Please upload the below to the applications Y/105/19 and Y/106/19: Planning Correspondence.

From: Maria Tomalova
Sent: Wednesday, July 1, 2020 11:26 AM
To: Ben Daines <[REDACTED]>
Subject: RE: Stakers Farm

From: Ben Daines <[REDACTED]>
Sent: 26 June 2020 14:26
To: Maria Tomalova <Maria.Tomalova@arun.gov.uk>
Cc: Daniel Vick <Daniel.Vick@arun.gov.uk>; Chris Barker <[REDACTED]>
Subject: RE: Stakers Farm

Subject: Stakers Farm

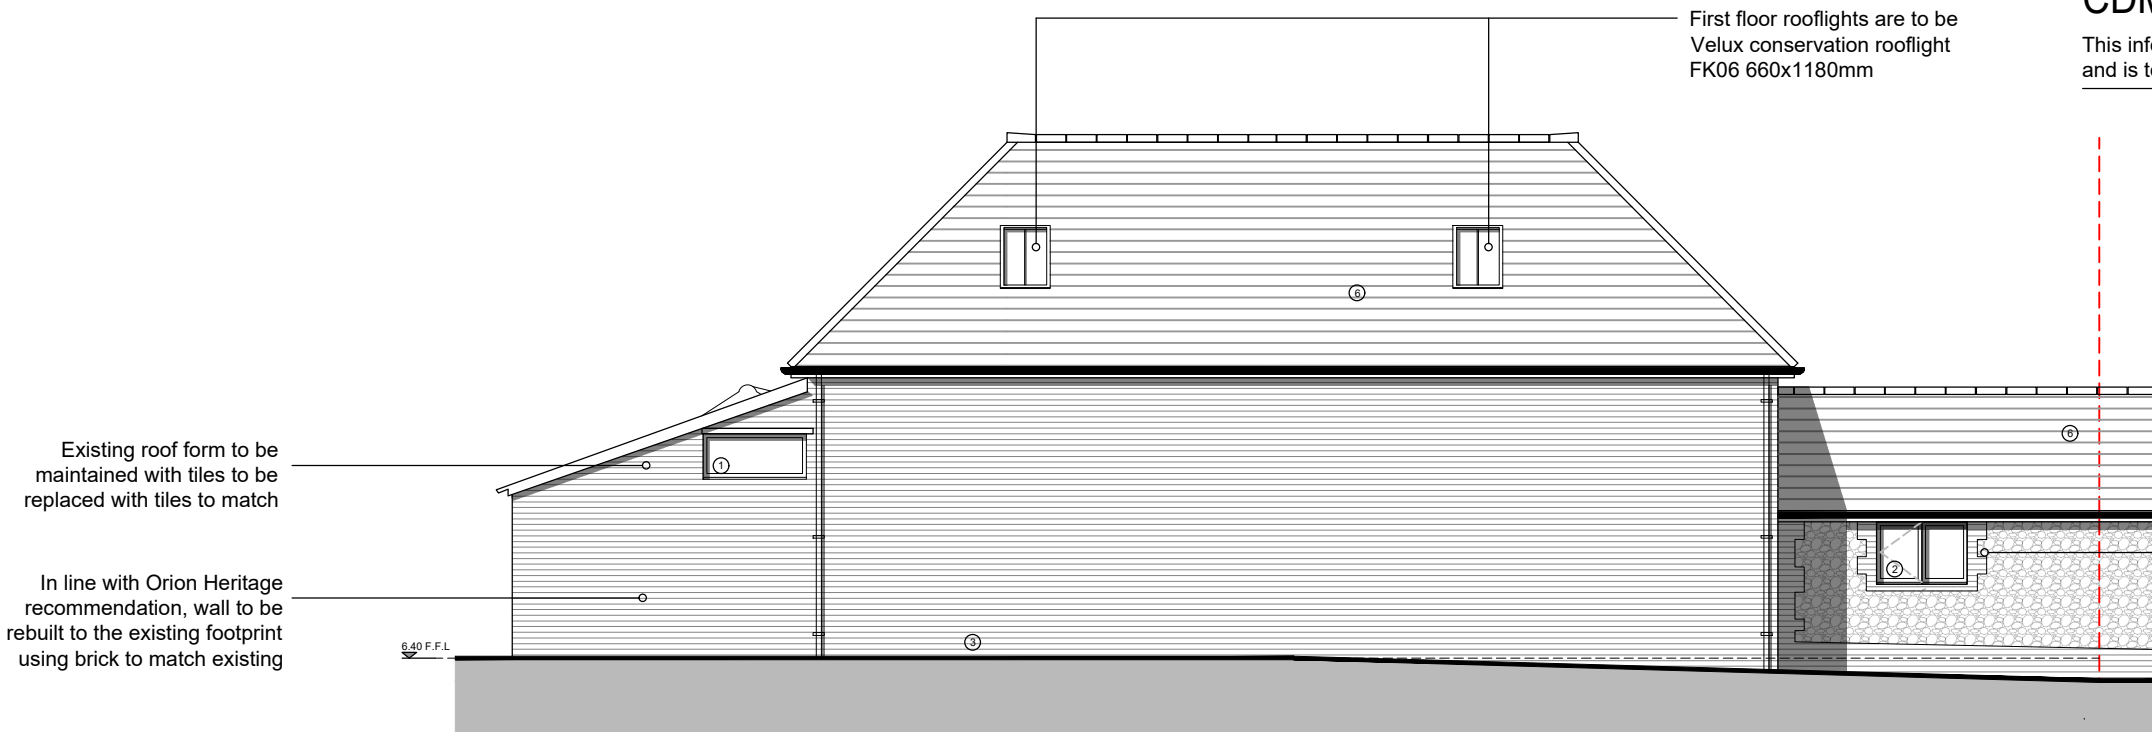
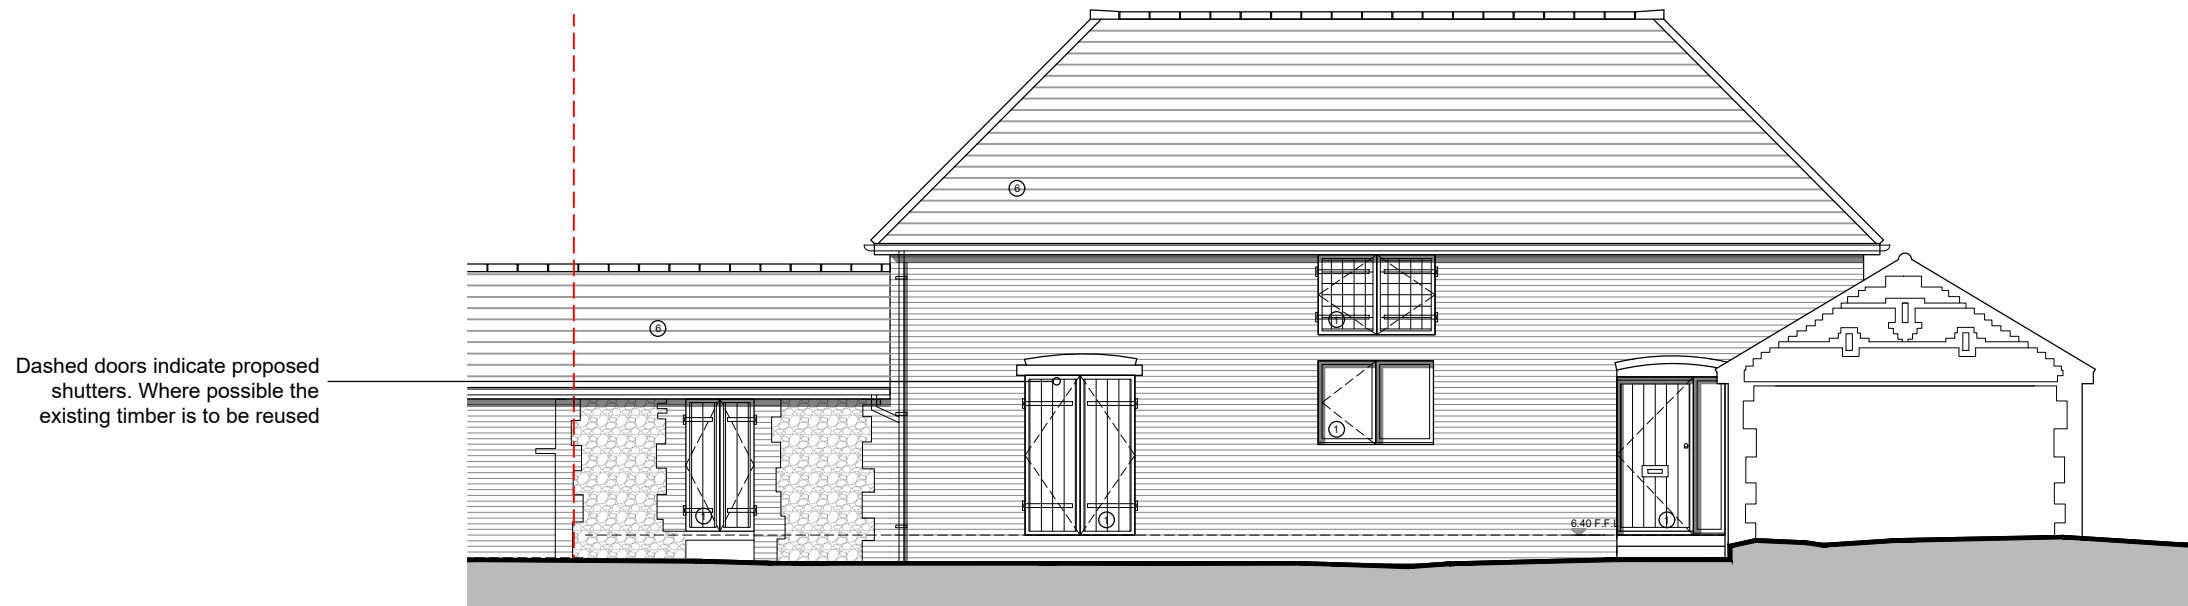
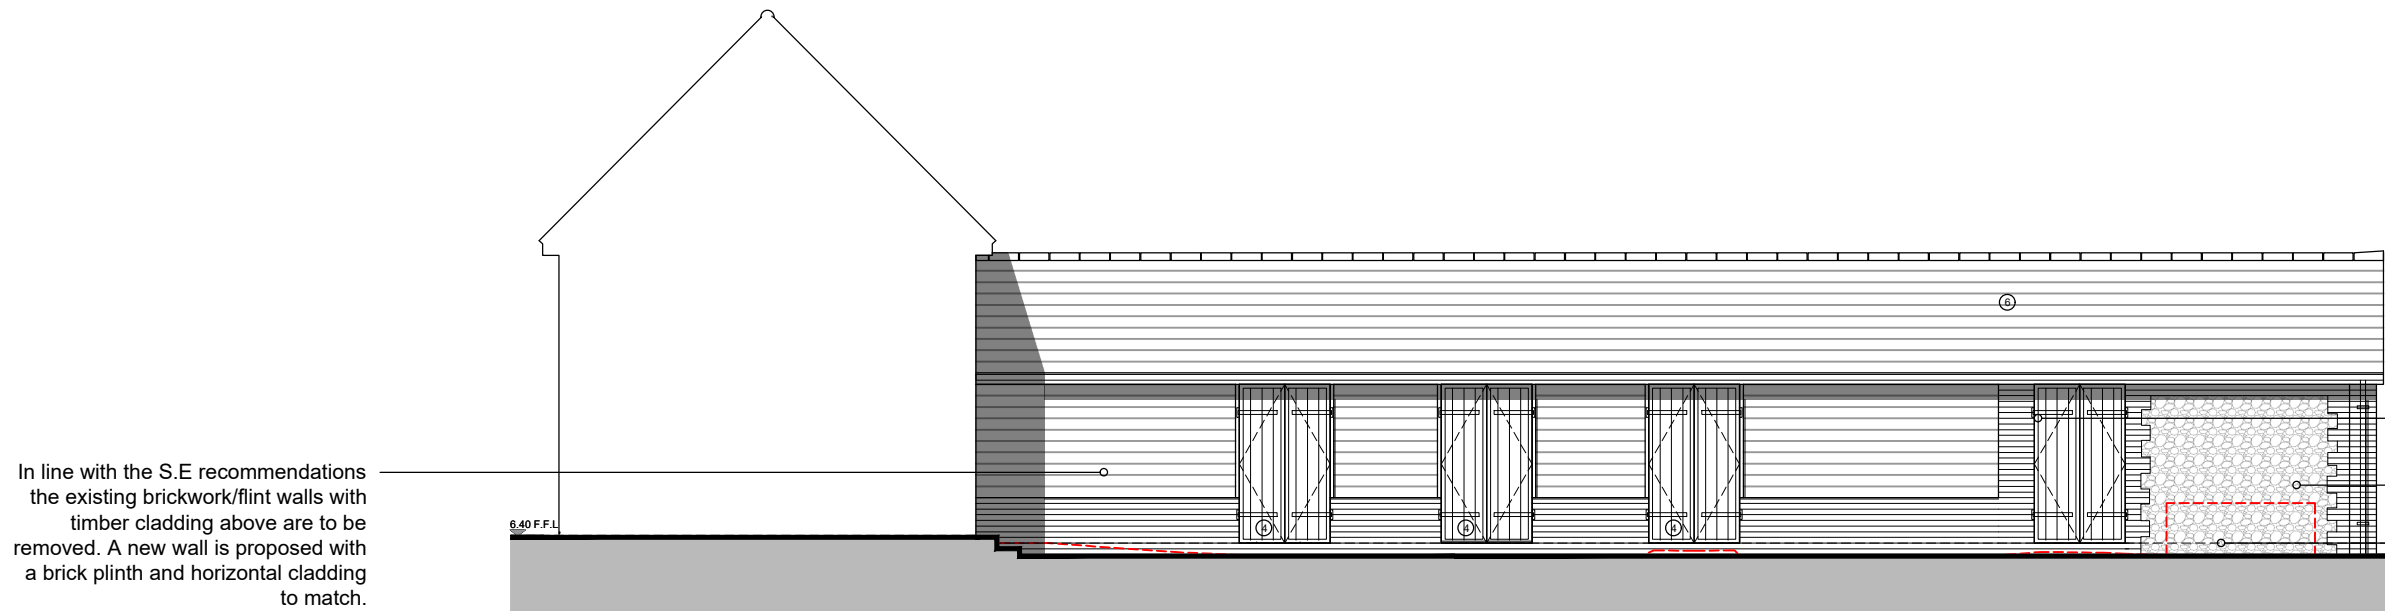
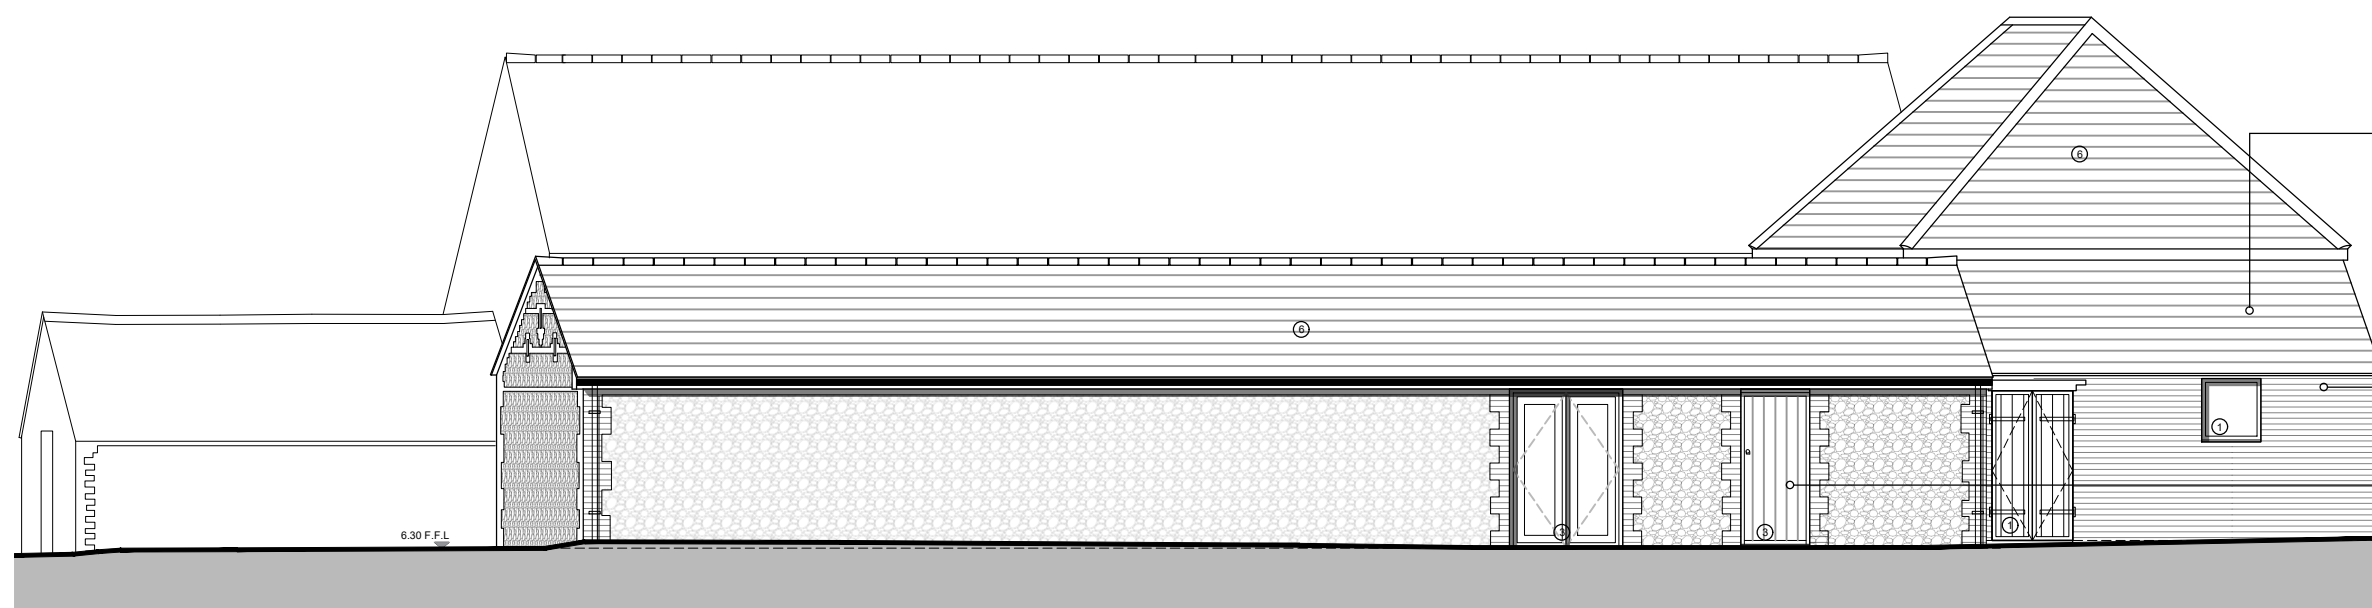
- Amount of conservation rooflights reduced to just two (one per bedroom) located on less prominent north western elevation.
- South elevation amended so size and position of new windows and doors reflect existing.

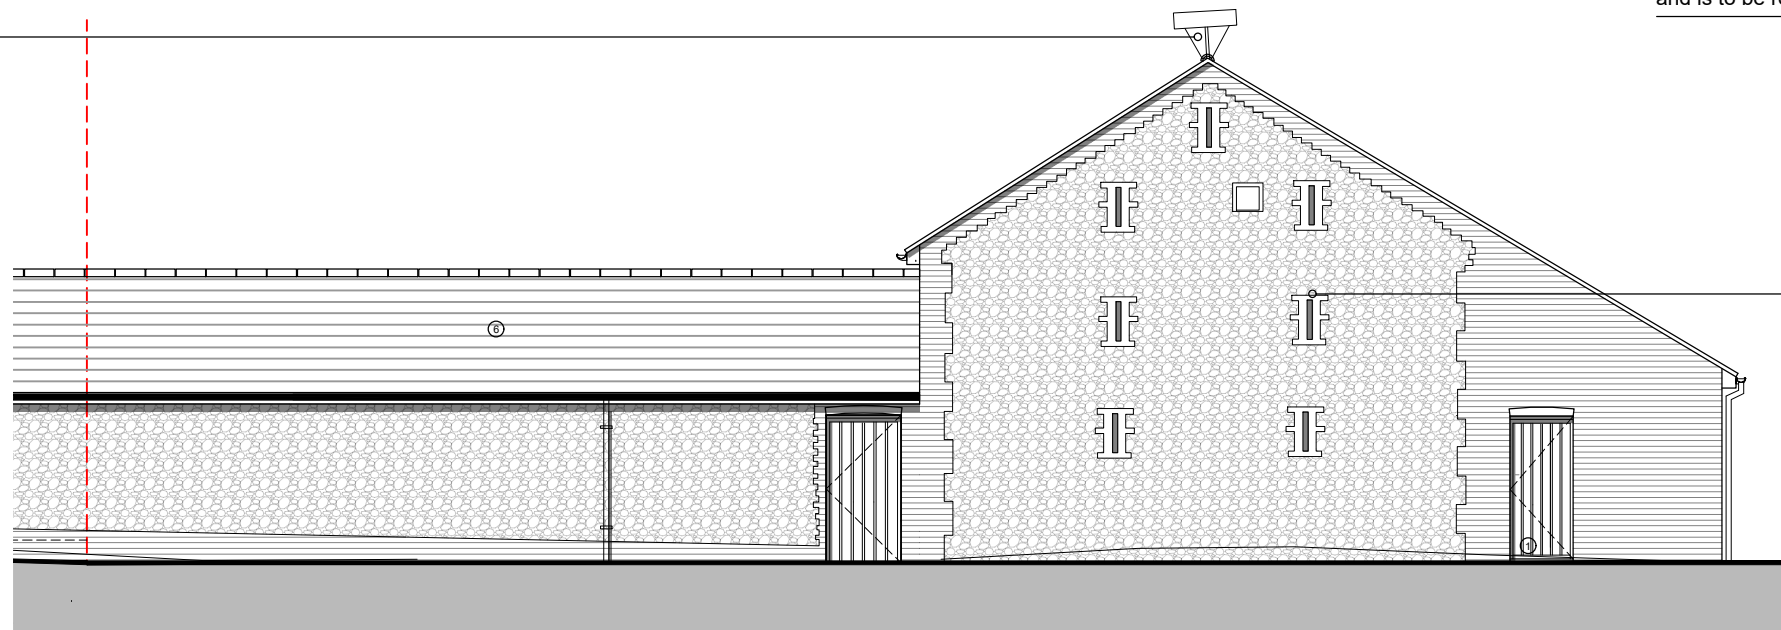
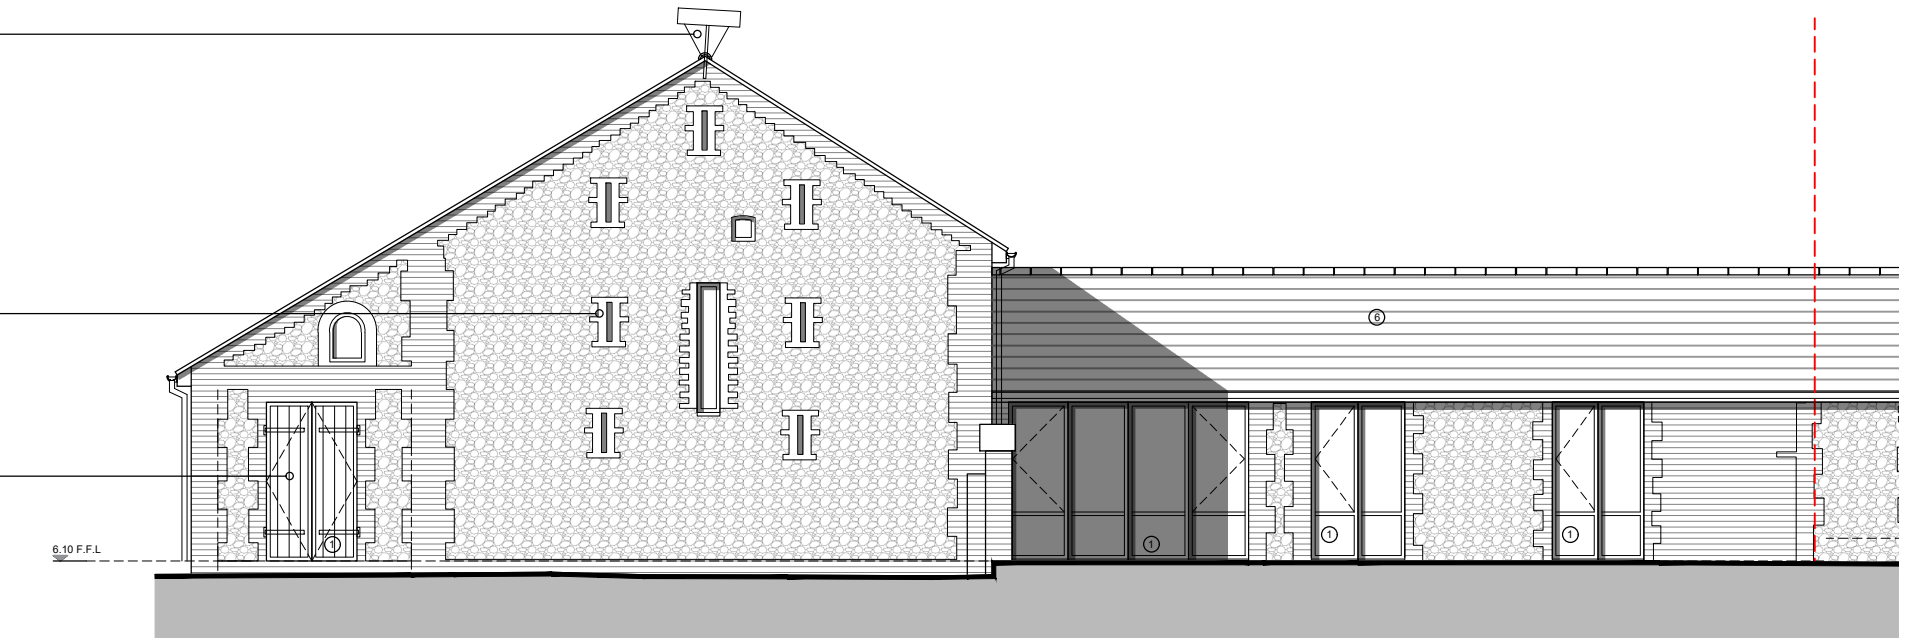
- Windows on east elevation of single storey element reflect the existing openings as closely as possible.
- South elevation – the size/number of doors on the south elevation have been reduced in size to reduce the impact as far as possible whilst allowing access to the courtyard.
- North elevation – the number of rooflights has been reduced as per our telephone conversation in early April.
